Engineers Comments Regarding Condition 11- surface water drainage

APPLICATION **R/229/18/DOC**

Site Address: Fleur De Lis Station Road Rustington BN16 3BH

Description of Works: Approval of details reserved by condition imposed under R/269/15/PL relating to condition 11-surface water drainage.

Scale: 1:125	Paper Size: A1	Date: JUNE 2017	Drawn By: JH	Checked By: CH
Project No. RRL012	Drawing No. 505	Revision: P6

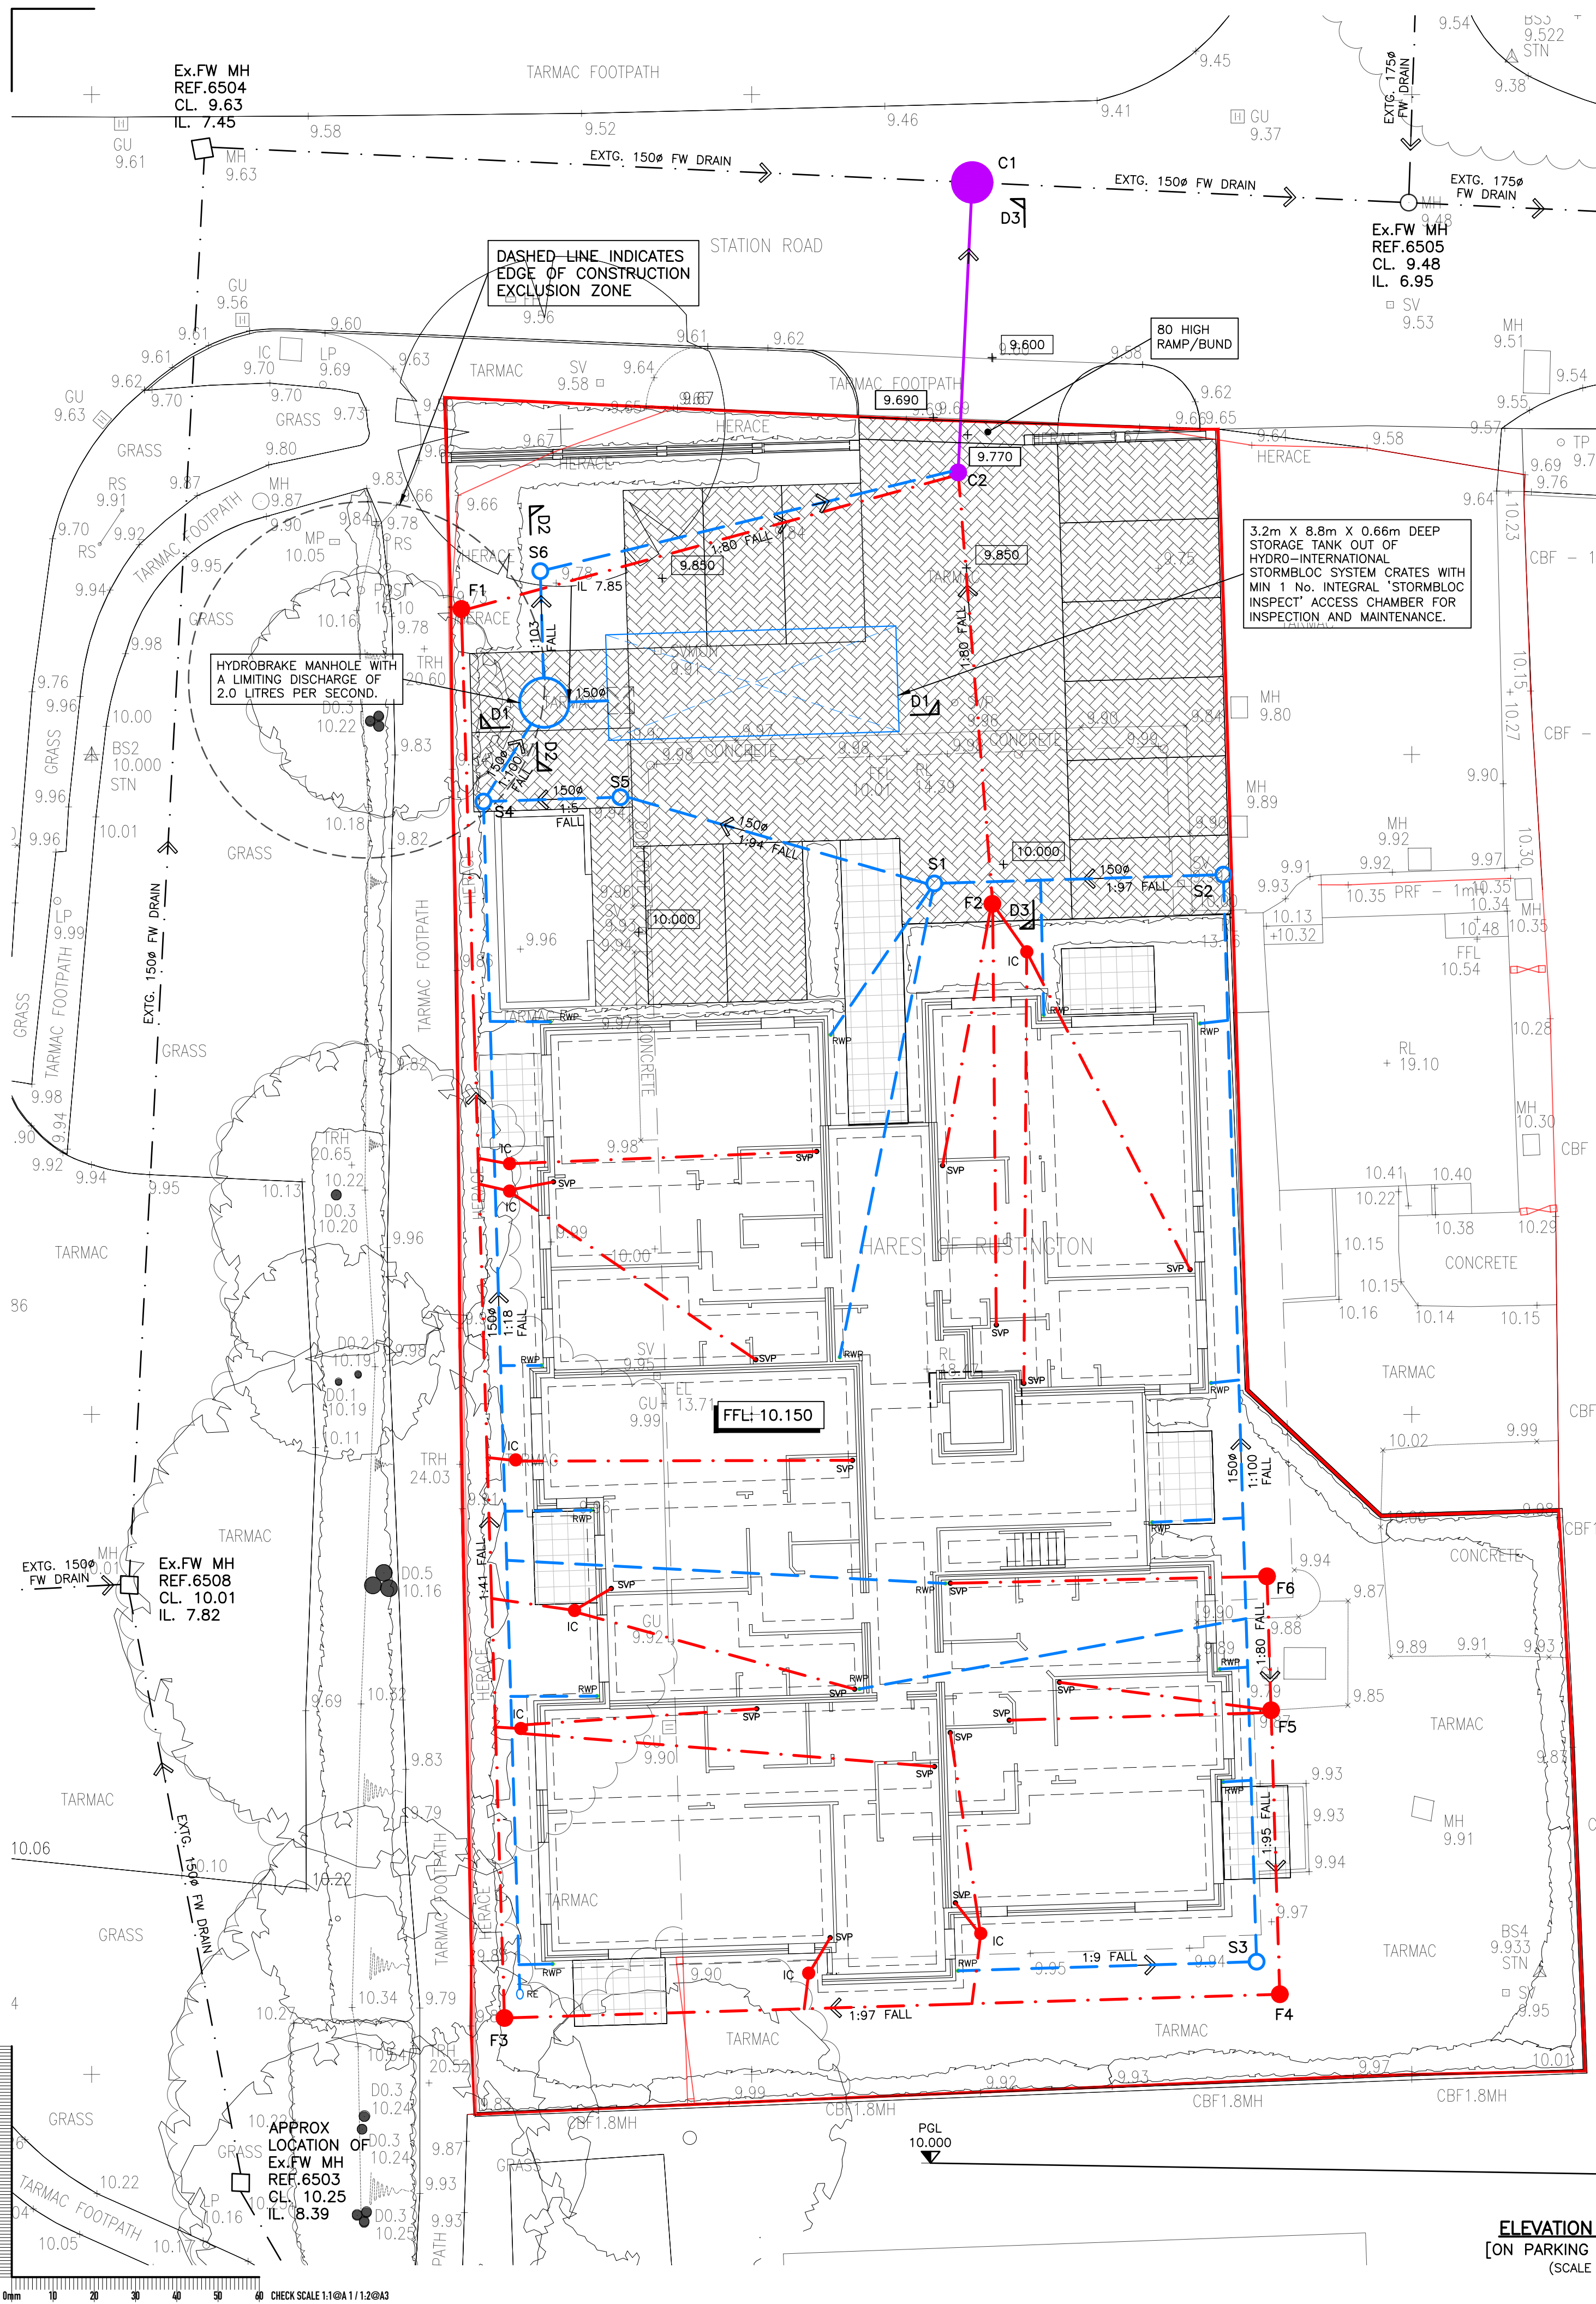
The groundwater monitoring and infiltration tests supplied support the use of shallow infiltration. Permeable paving is specified however, this is only to drain the paved areas themselves. I have the following comments:

1. Despite my previous comments, infiltration testing still was not completed in the winter.
2. Please submit proof that there is insufficient room to take roof water to permeable pavements and therefore demonstrate the need for attenuation and discharge to foul.
3. Please provide calculations demonstrating that the attenuation and permeable paving is appropriate to contain the 1 in 100 year +cc event.
4. Please provide construction details of the permeable paving, please also provide finished and formation levels on the plan.
5. Please provide construction details of the attenuation tanks which include surround details and cover details.
6. Please provide construction detail drawings of manholes.
7. Please provide construction detail drawings of pipe bedding and surround.
8. Please supply the connection agreements from southern water.
